STATE OF WASHINGTON
DEPARTMENT OF ECOLOGY

March 15, 2021

Re: SEPA Register 202101042, CU-20-00006

Thank you for the opportunity to comment on the Pre-Threshold Consultation for the establishment of the Swiftwater Storage 12 mini warehouse facilities, 3 carport style roof-over-concrete structures, uncovered boat and RV storage and a single family residence, proposed WLC Property Holdings, LLC. The Department of Ecology (Ecology) has reviewed the environmental checklist and has the following comments.

WLC PROPERTY HOLDINGS LLC
SITE PLAN

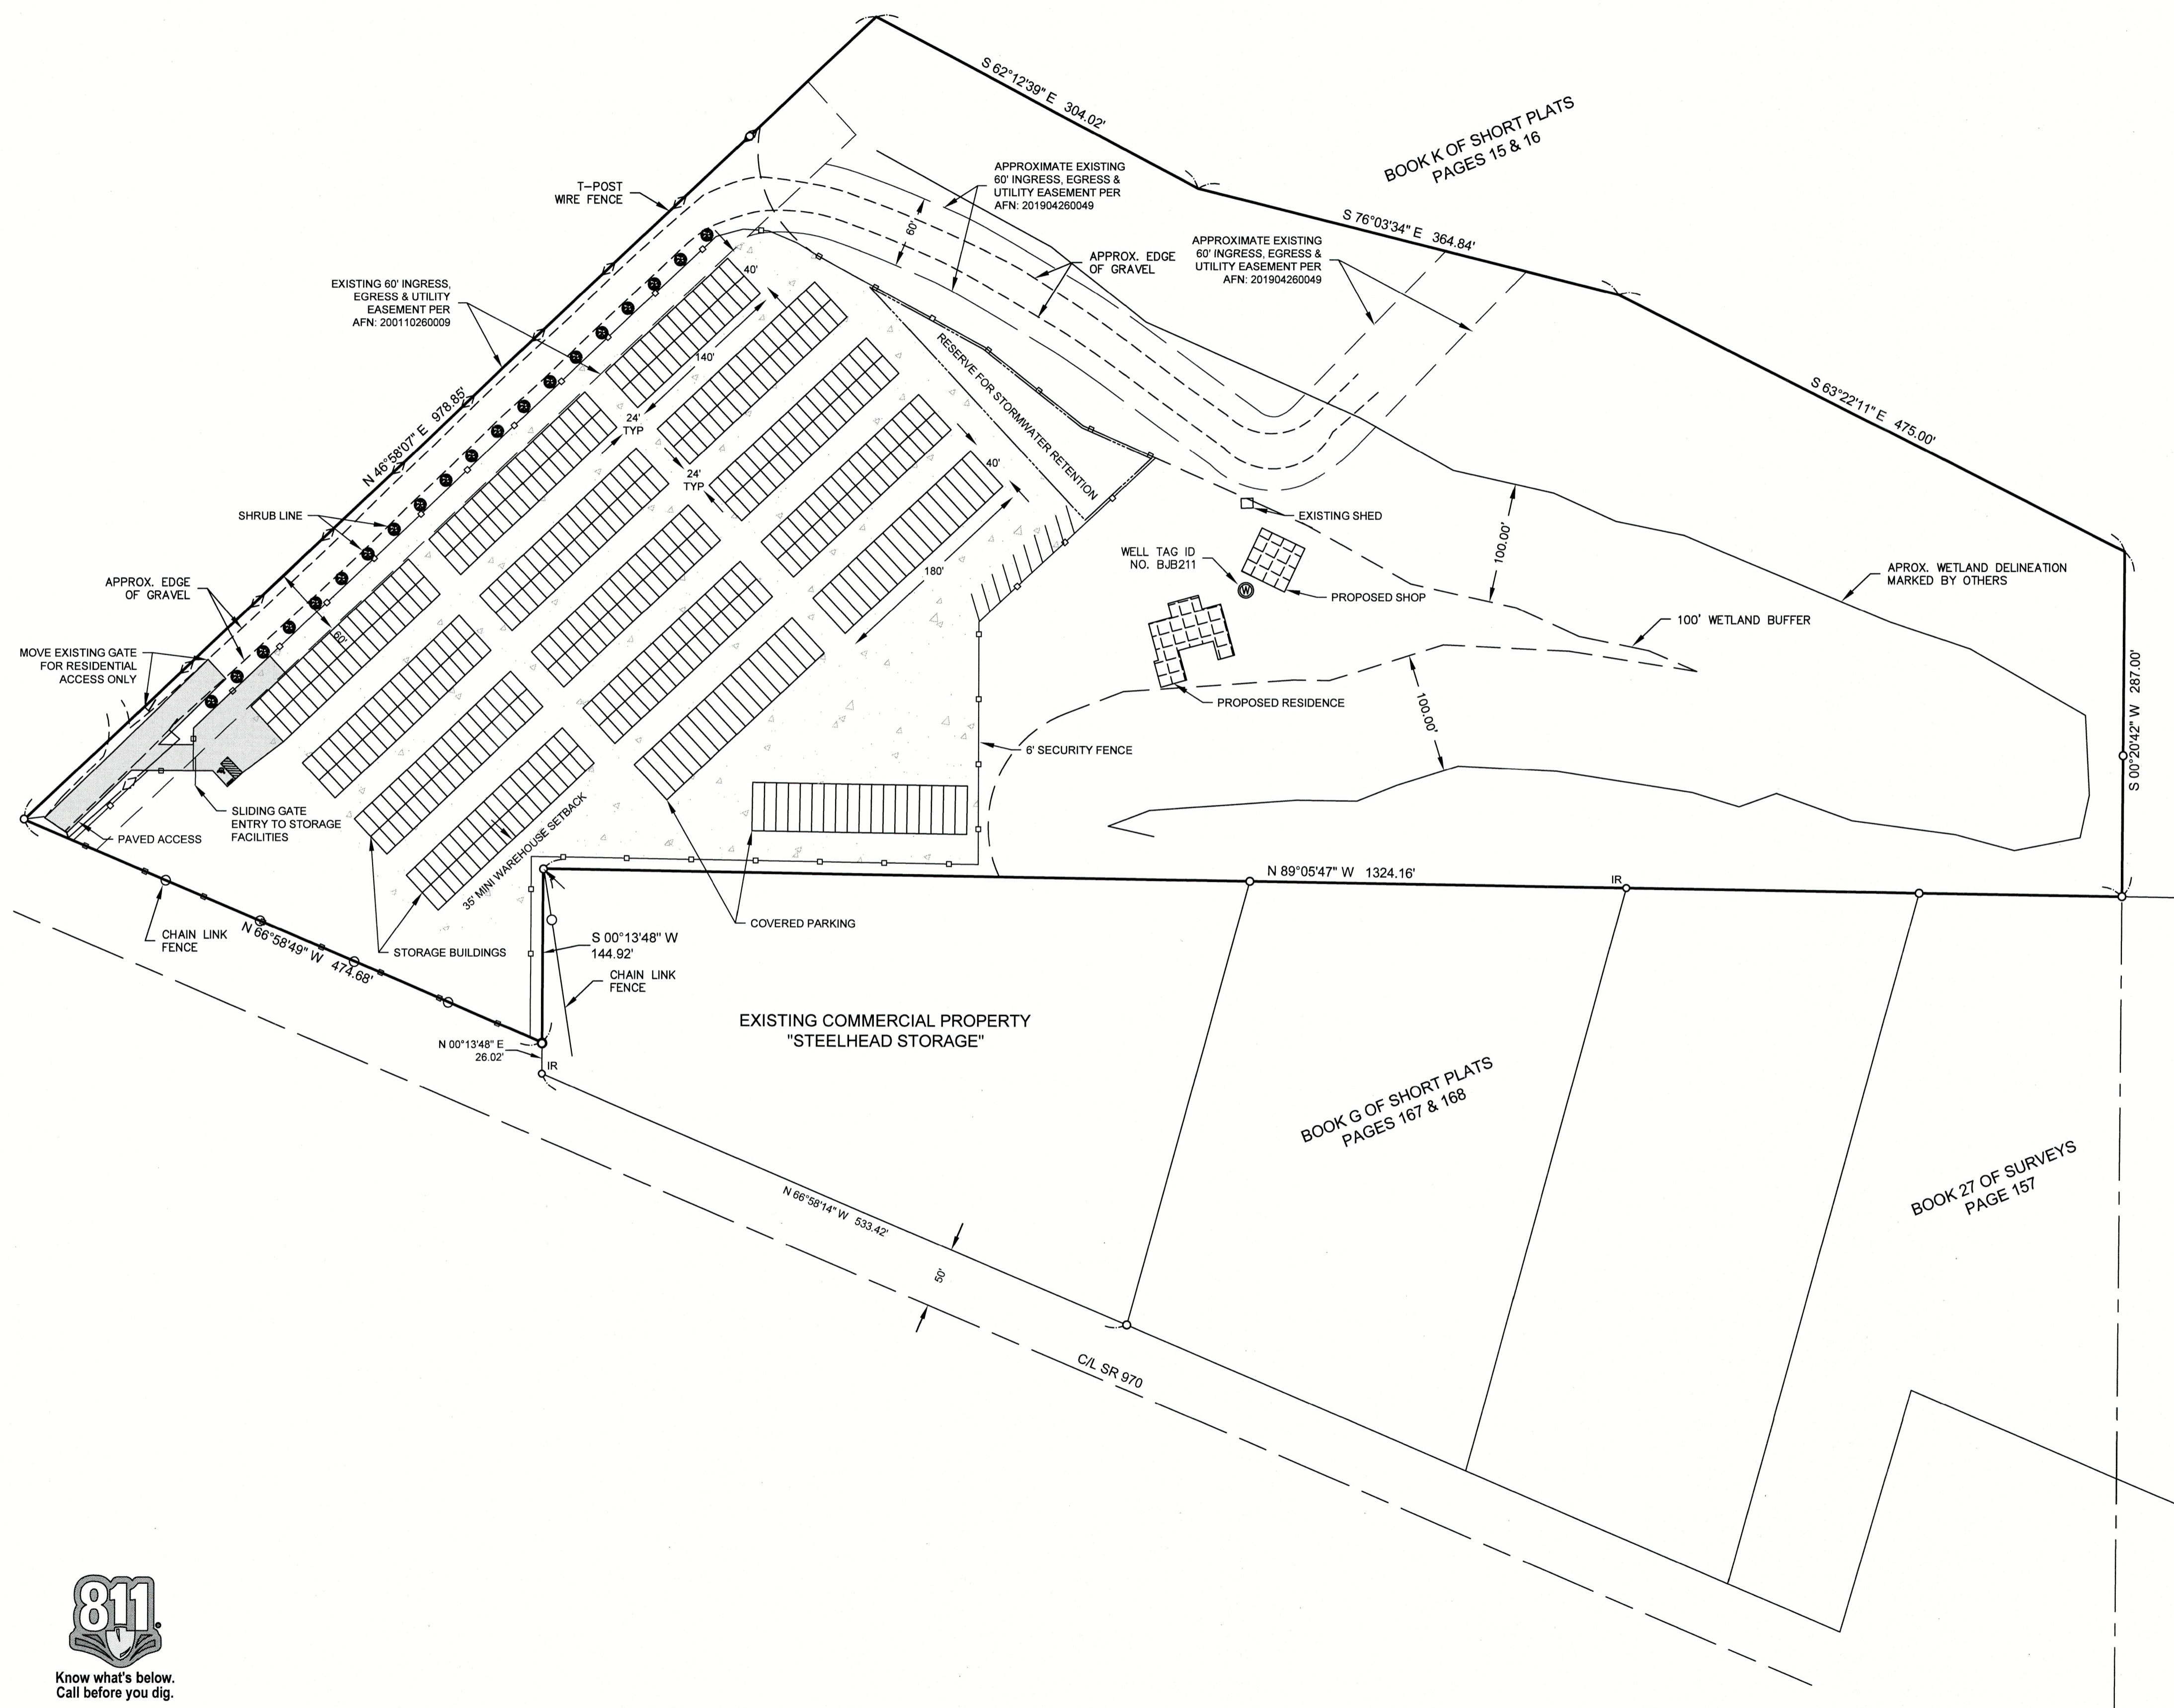
Upon reviewing the October 12, 2020, Critical Area Report for Parcel 15445, conducted by Sewall Wetland Consulting, Inc. Ecology staff would like to request a joint site visit with County to verify the wetland boundary. The delineated wetland boundary was not provided within the critical area report. It is unclear where the boundary of the wetland is proposed. Ecology recommends the County request a detailed map demonstrating the wetland boundaries prior to conducting a joint site visit.

The buffer width should be vegetated prior to construction. As there is a change in landuse the buffer must be planted. Without a planted buffer the storage unit should be located even further away from the wetland. Planting the buffer will reduce noise, dust and other pollutants from entering the wetland, and provide structure adjacent to the wetland.

Ecology recommends the County request a copy of the proposed wetland boundary lines, set up a time for a joint site visit this spring, and request a buffer planting plan for those area located within the buffer that will not be impacted, and a mitigation plan for those area within the buffer that will be impacted. We look forward to continuing to work with the County in the protection of their critical areas and implementation of their wetland codes. Please contact **Lori White**, at (509) 575-2616 or lori.white@ecy.wa.gov, should you have any questions regarding the above comments.
